6th August 2019

Extension of existing conservatory. Replacement of dormer windows and damaged guttering. Removal of defective render exposing the original brickwork. Reinsitatement of infilled window, replacement windows, installation of sun tunnels, replacement flat roof, external refurbishment and alterations to entrance gate/steps.

Avola House 16 Tarrant Street Arundel

Thank you for your internet representation made on 5th August 2019 which has been recorded as '**no objection**' with the comments as follows:

- PLANNING -
PROPOSED EXTERIOR GATE ELEVATION &
PLAN

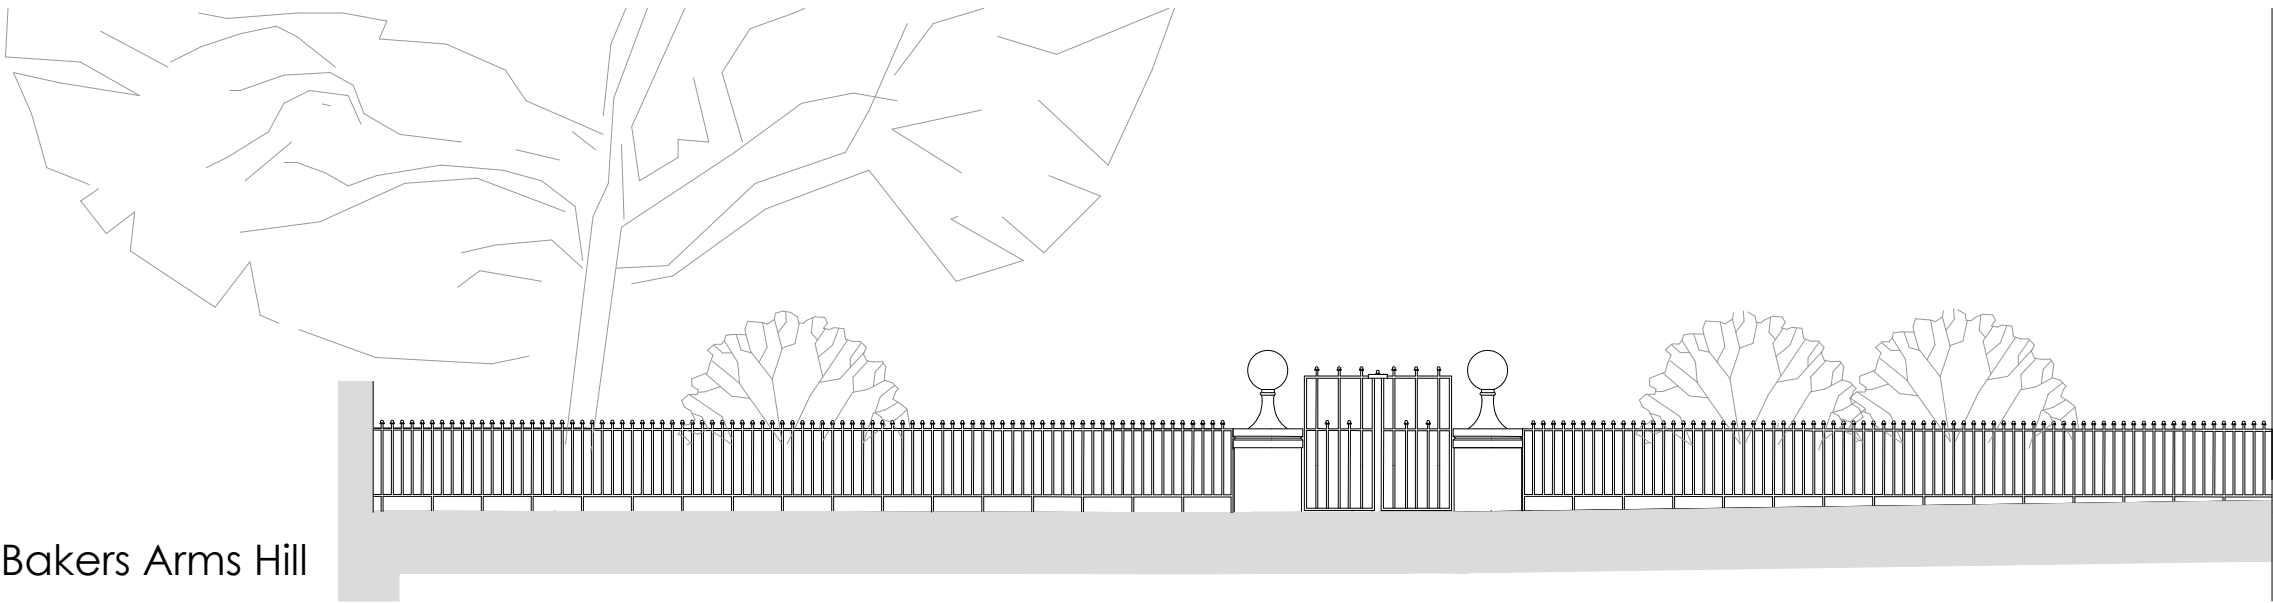
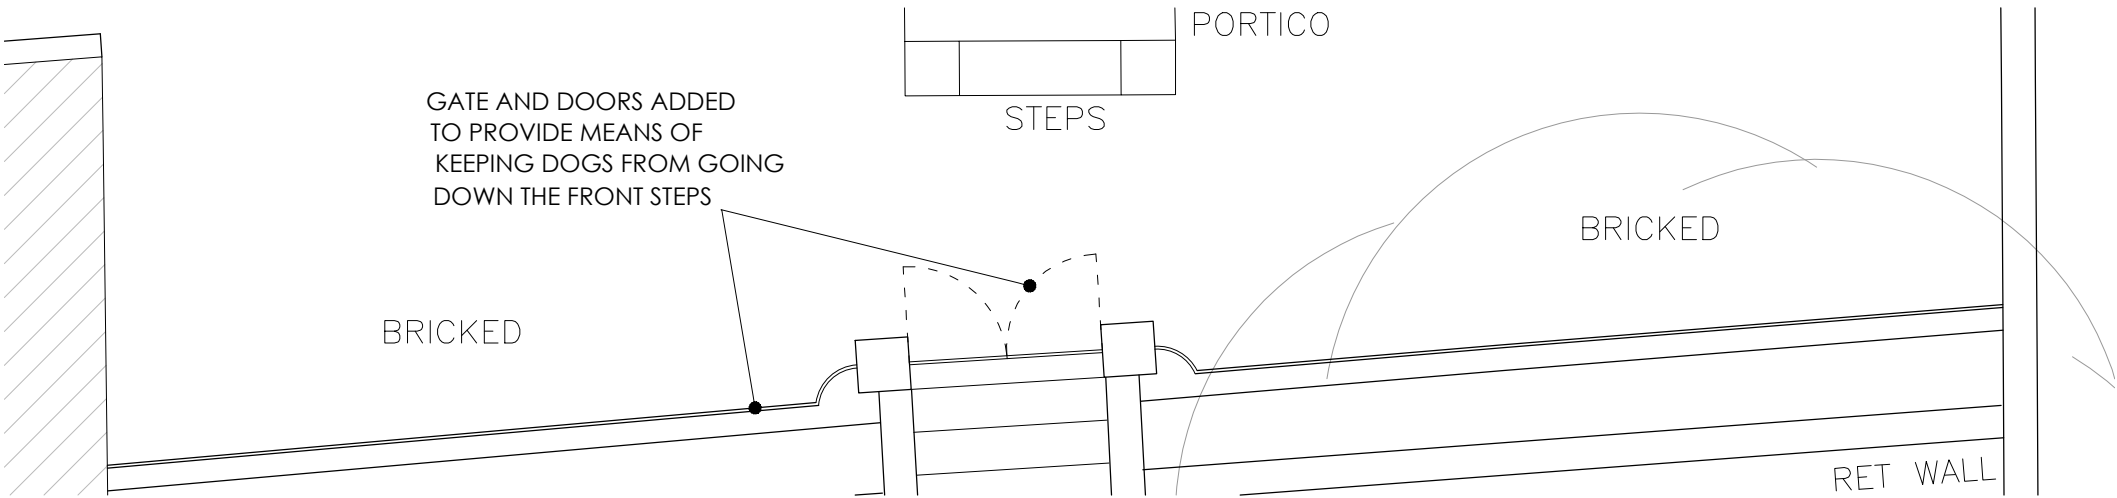
The only matter which perhaps needs further investigation is the heritage significance or otherwise of the blocked windows in the east elevation which are proposed to be opened up. If they were intended from the original construction of the building to be 'blind' windows, then they have considerable heritage significance; if infilled at a much later period, then there is likely to be little significance and their reopening presents no problem. If the Council is minded to grant planning permission/LBC then it is suggested that conditions be attached requiring the submission of precise details of all new joinery and a sample of the brick to be used in repair works. Perhaps larger scale drawings of the new iron balustrading and gates should also be required.
